February 9, 2022

**RE: Widefield Water and Sanitation District (WWSD, District)
Booster 2 Pump Station Replacement
Site Development Plan – Comment Response**

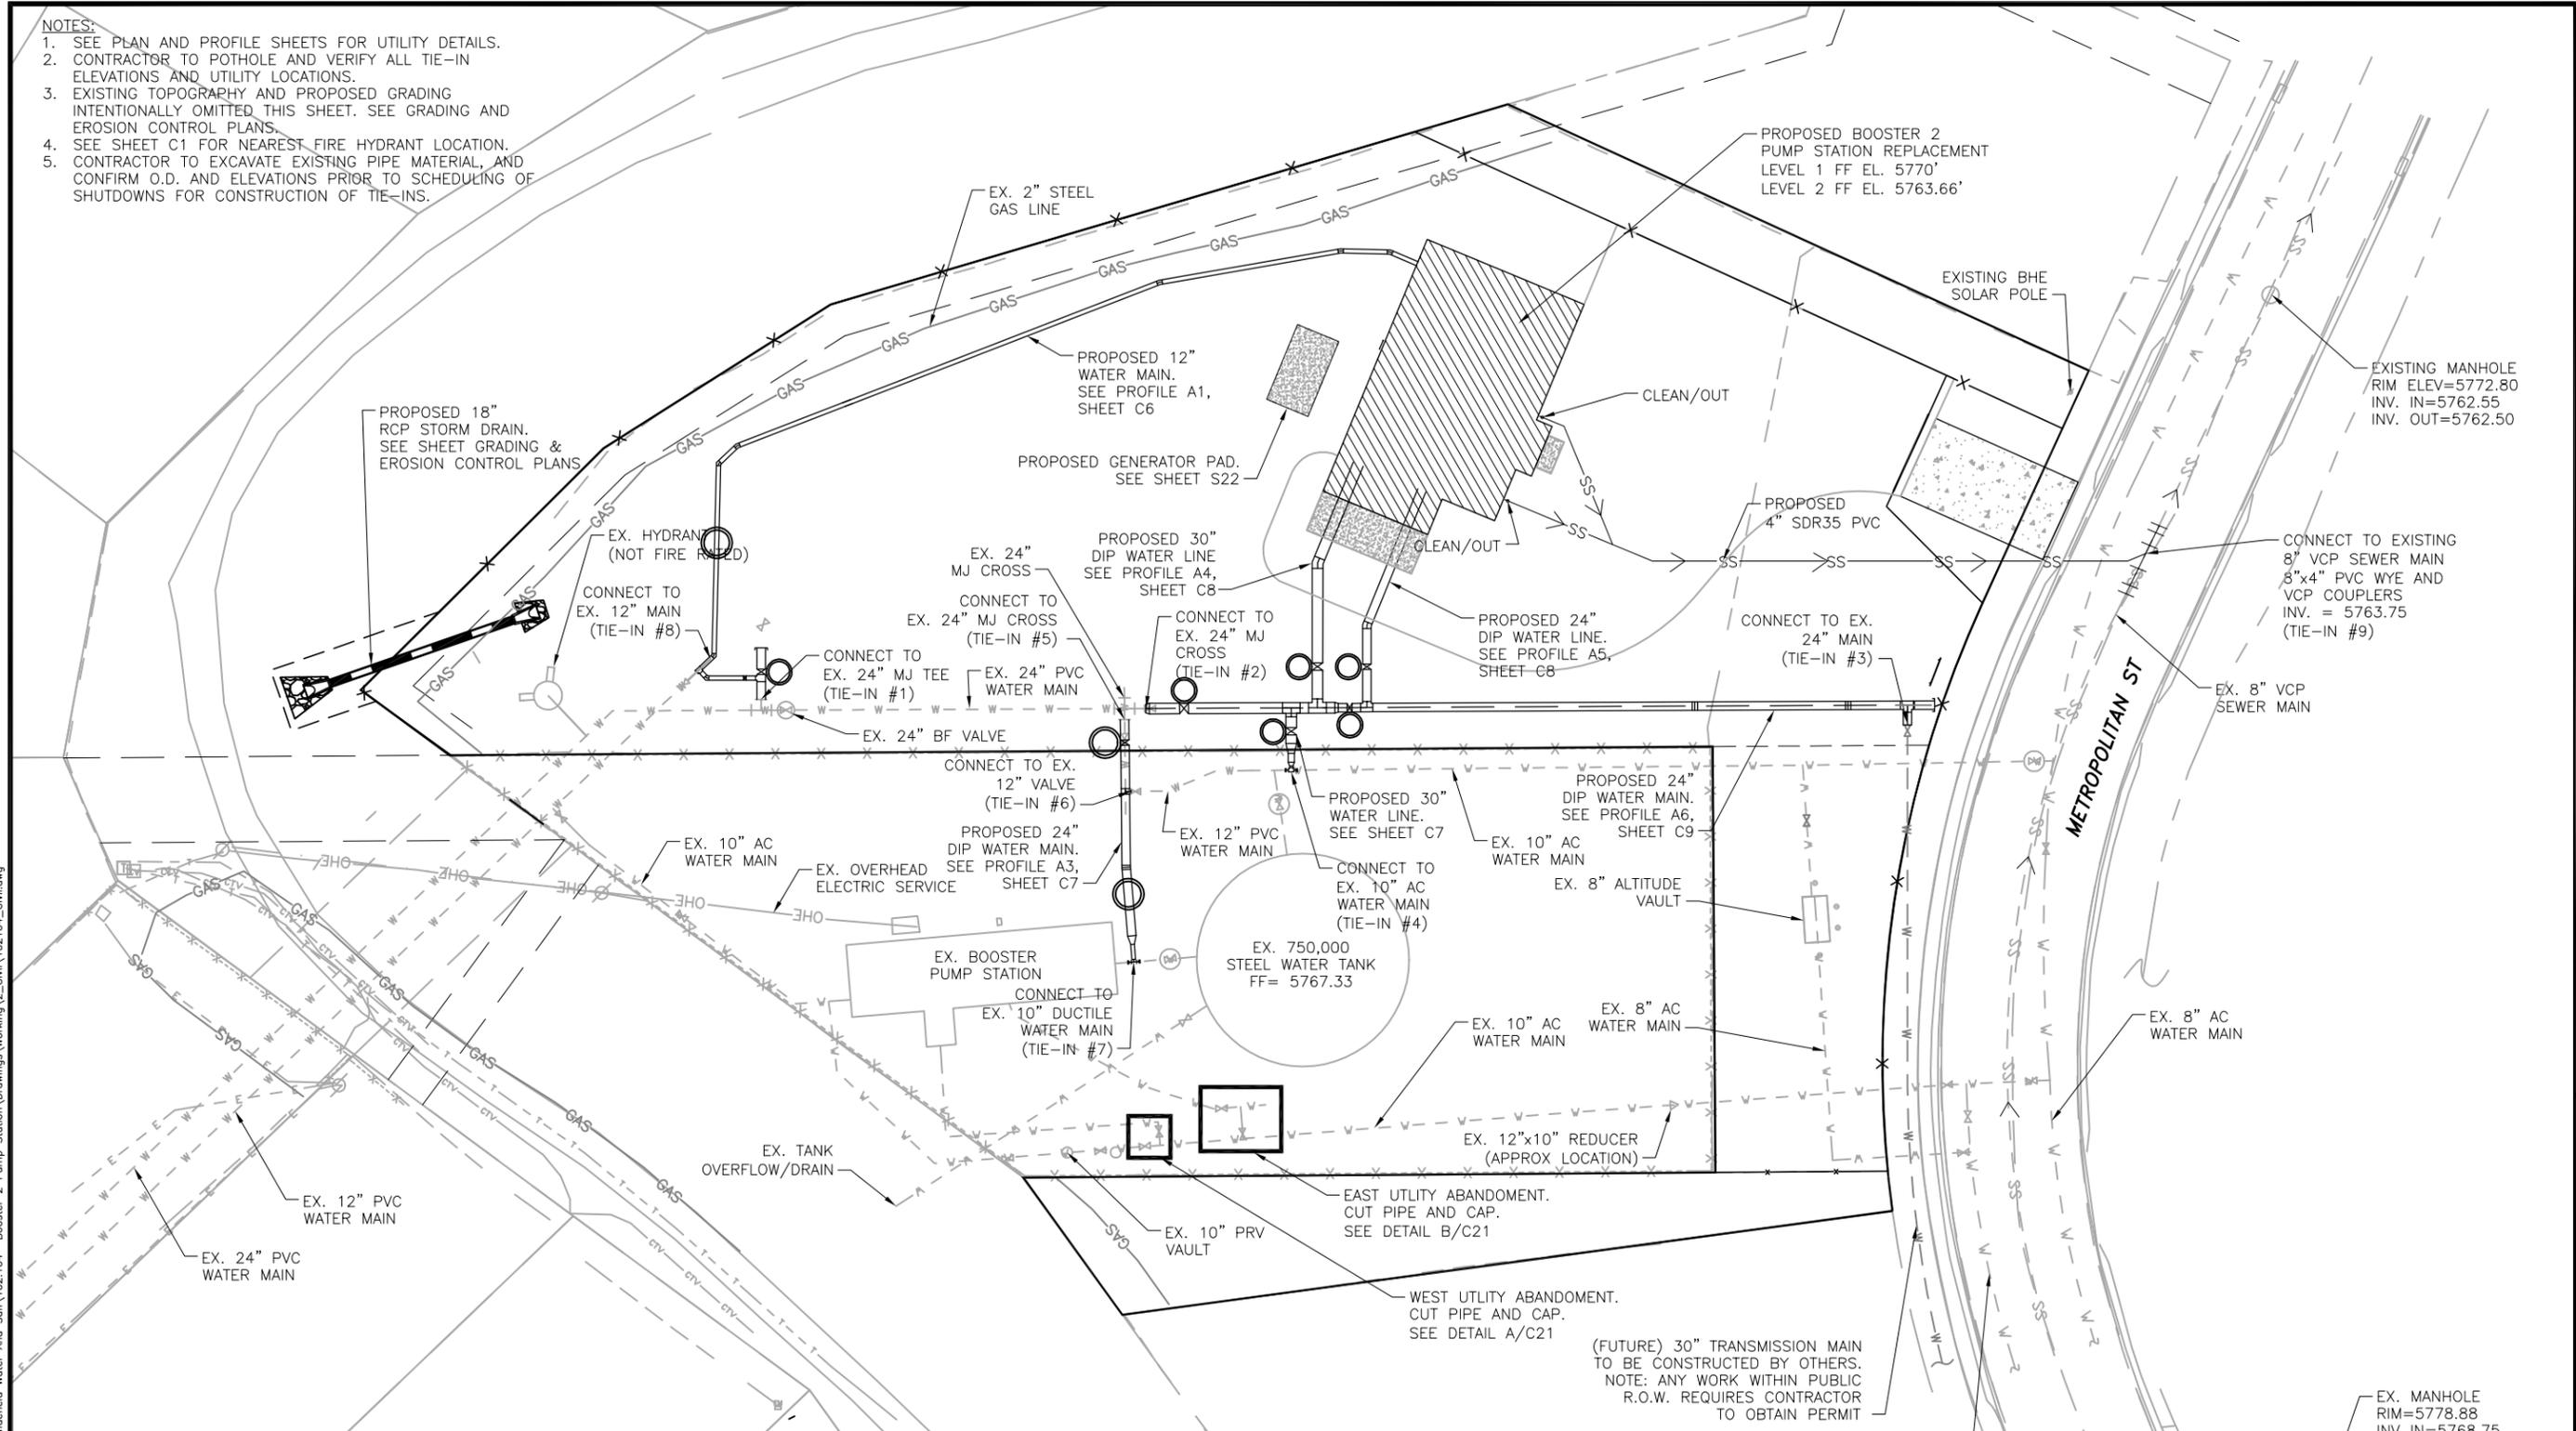
1. Site Development Plan (SDP) – please add the following:
 - Owner name, contact telephone number, and email for responsible party
 - Applicant name (if not owner), contact telephone number, and email for responsible party
 - Plan preparer name, telephone number, and email
 - Location and dimension of all property lines, rights-of-way, and all existing and proposed easements

Please note planned connection to the proposed 24” water main and new line construction has changed post Submittal 1. Future work within the right-of-way shall be by others. Refer to revised Sheet C5 for details and clarification.

C2
 SHEET ---OF

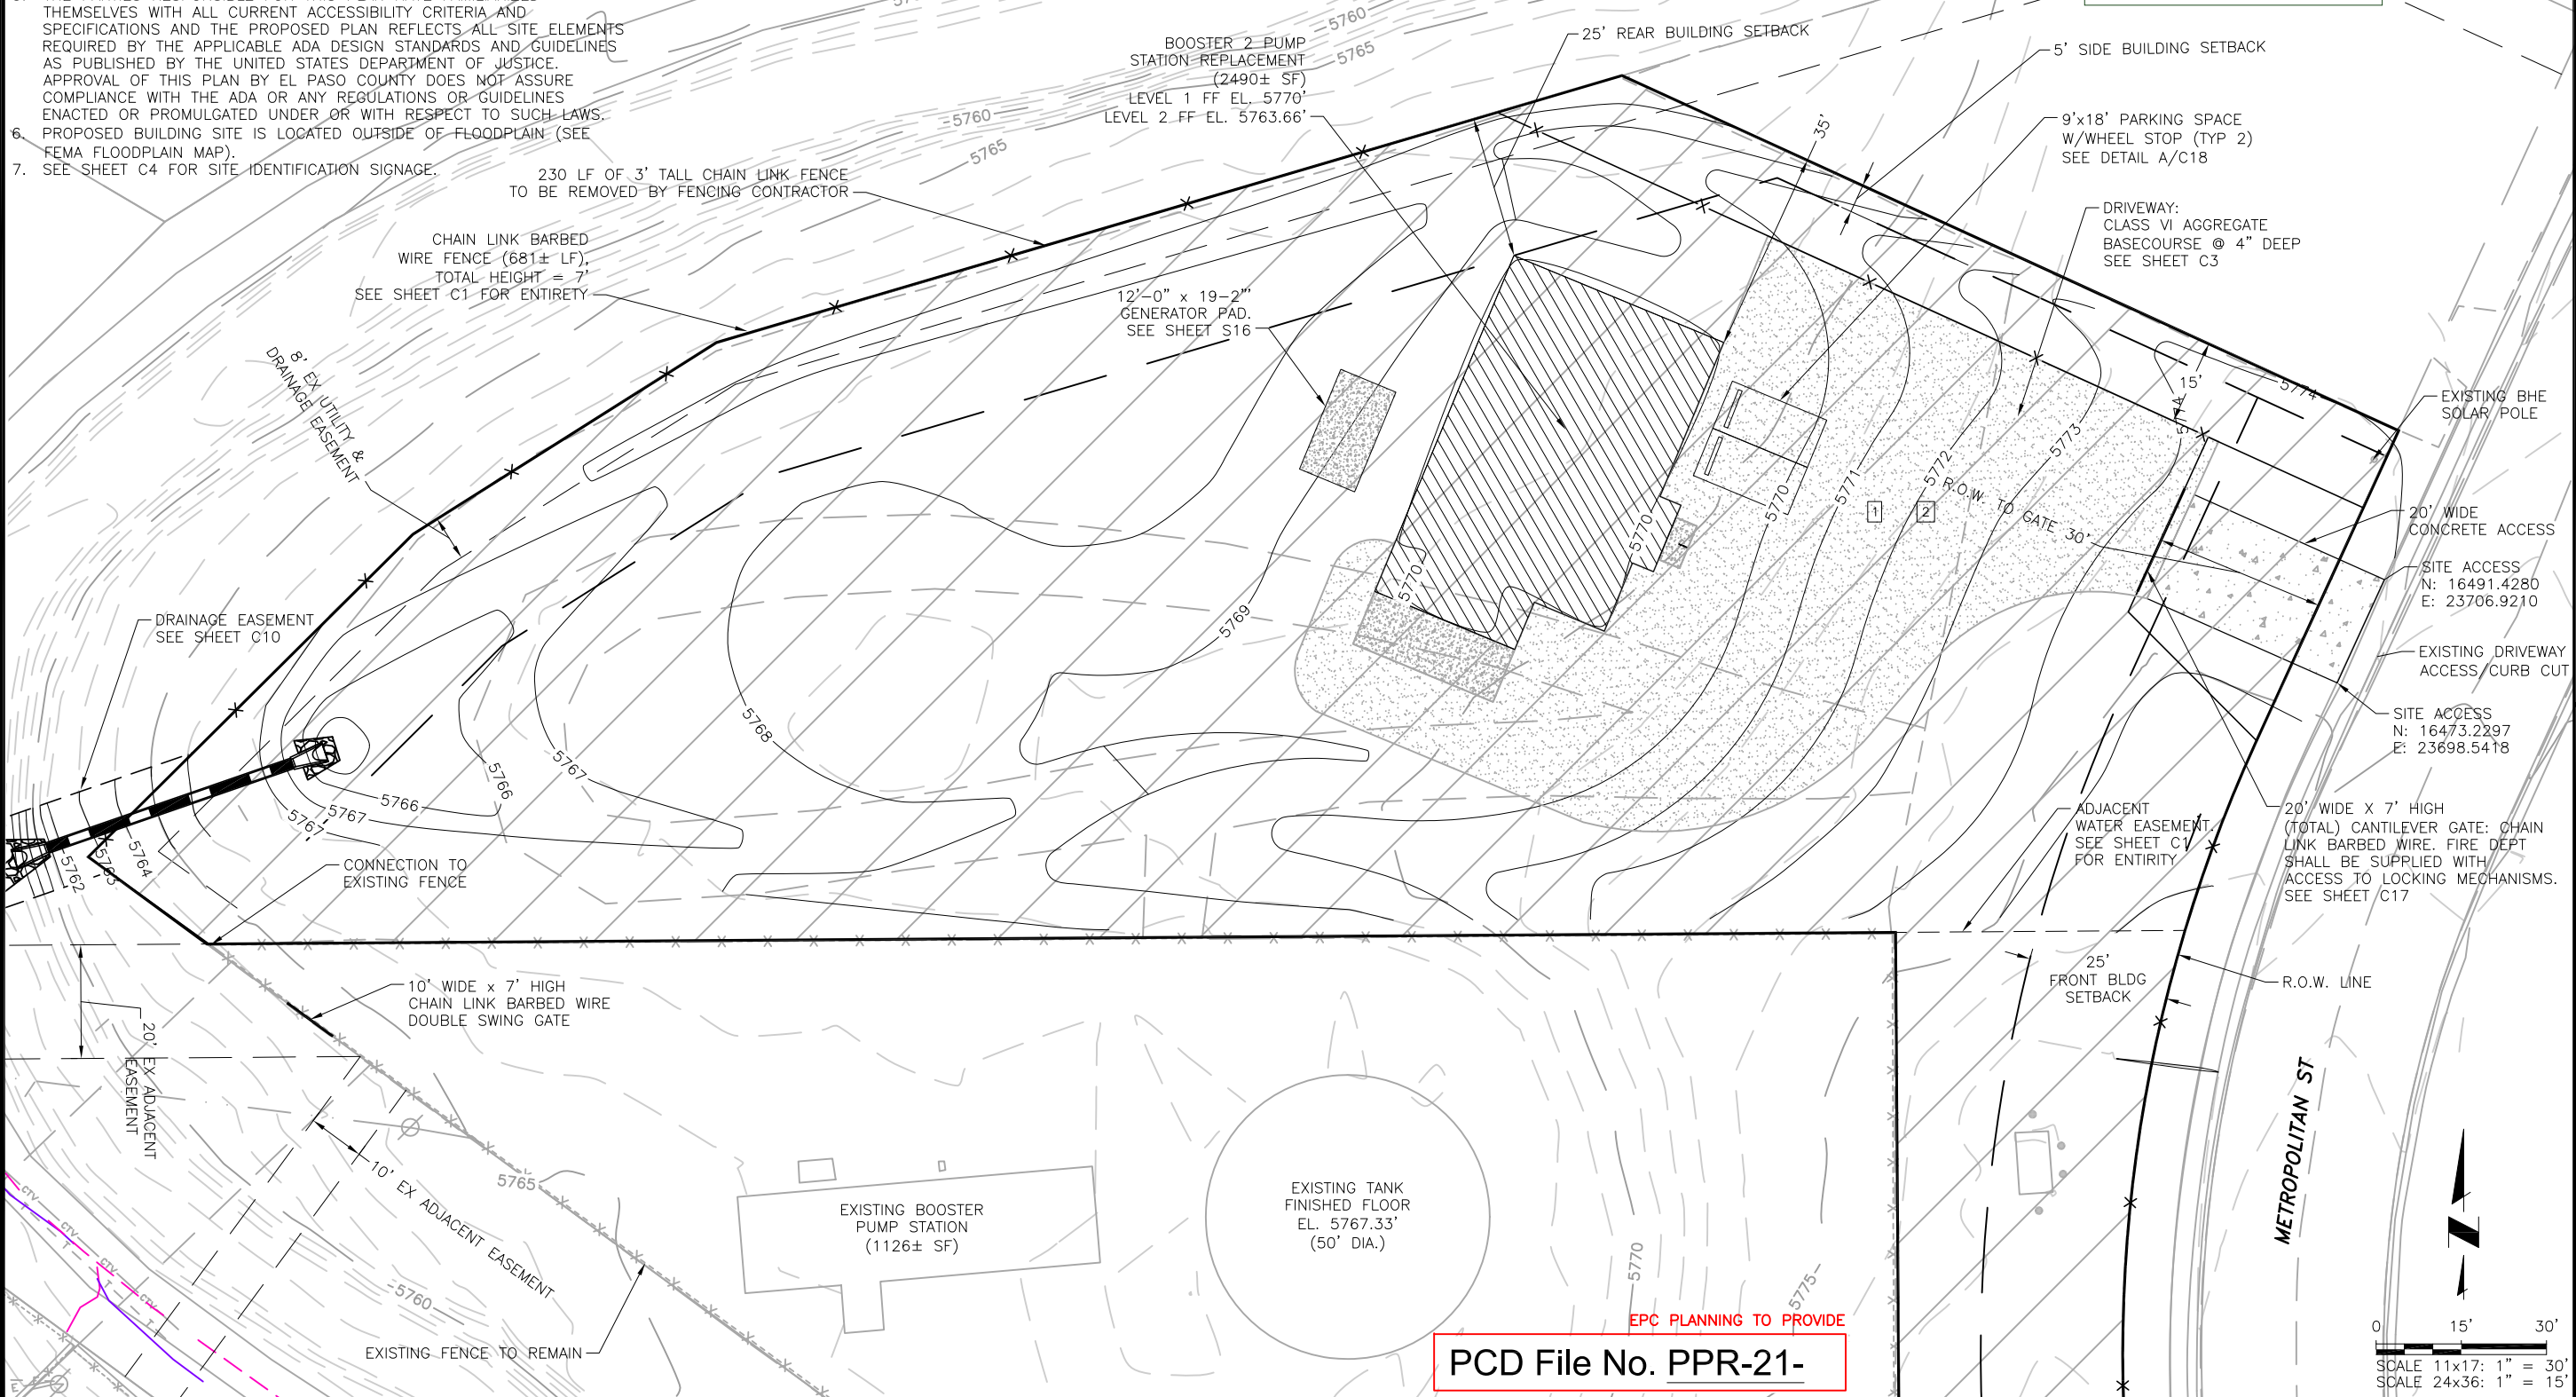
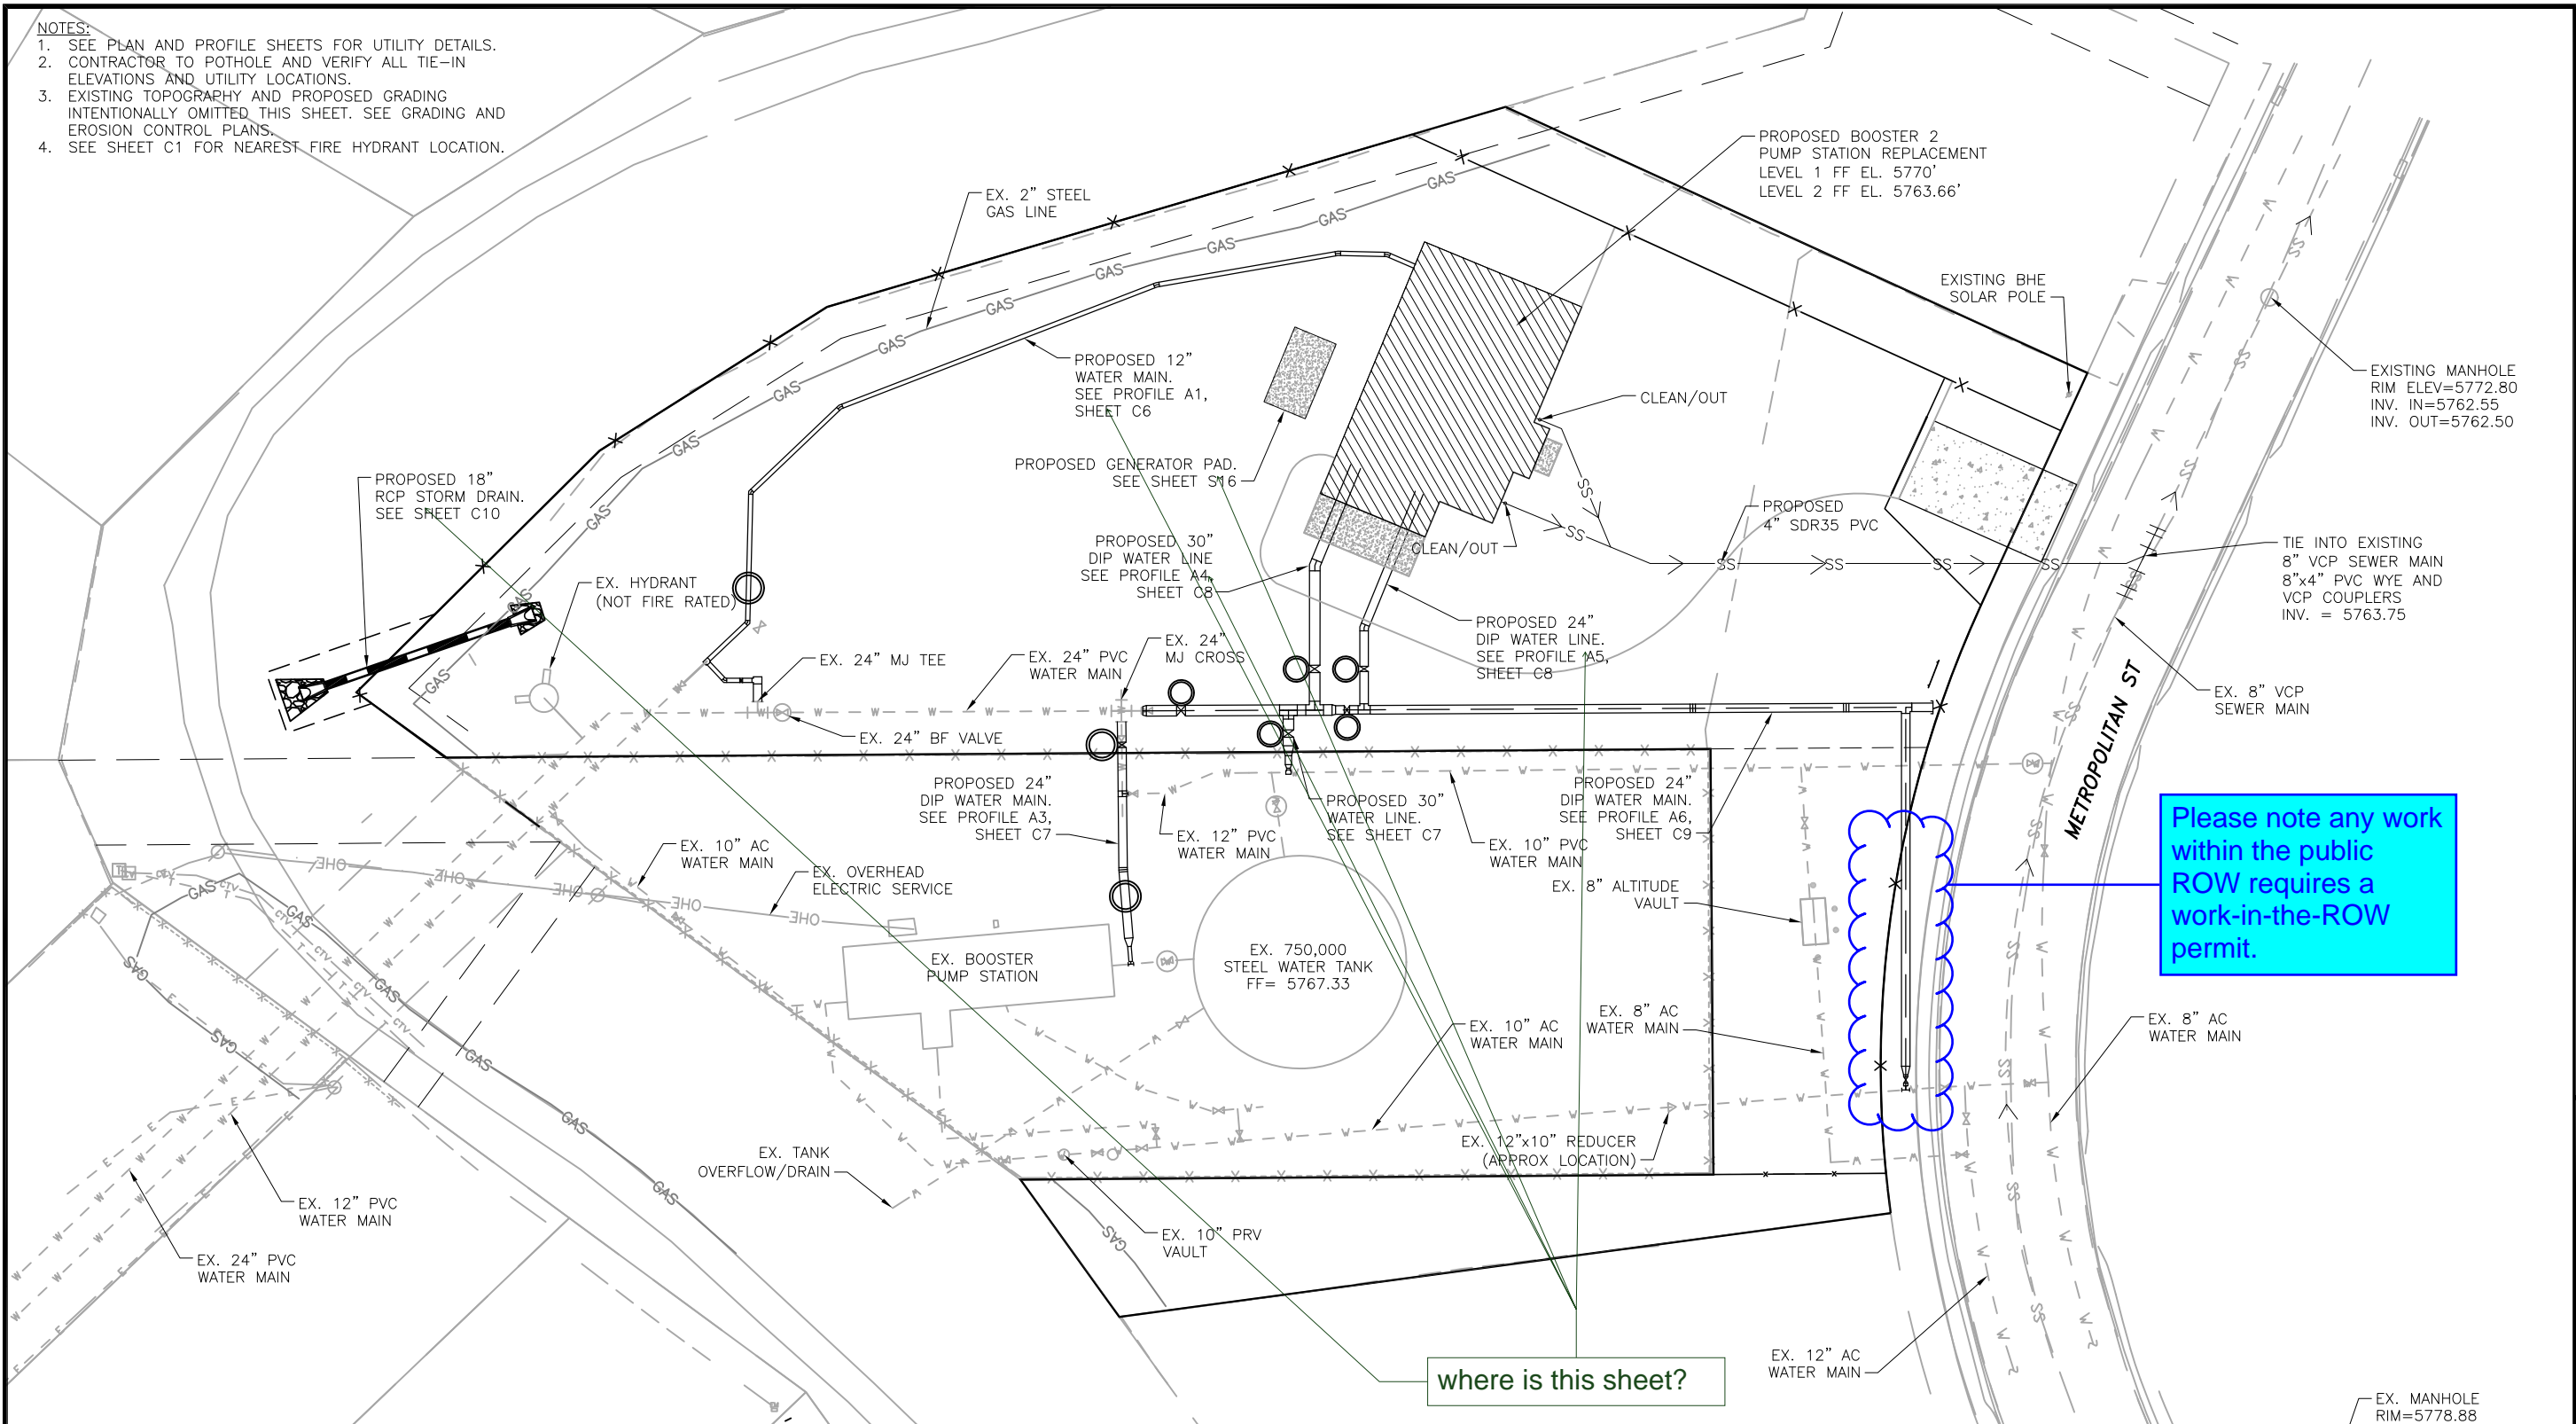
- The footprint of all existing and proposed buildings
- Add North arrow to Vicinity Maps
- Please note any work within the public ROW requires a work-in-the-ROW permit
- Where is this sheet (reference callouts)

See resubmitted SDP Plans for additional information requested.
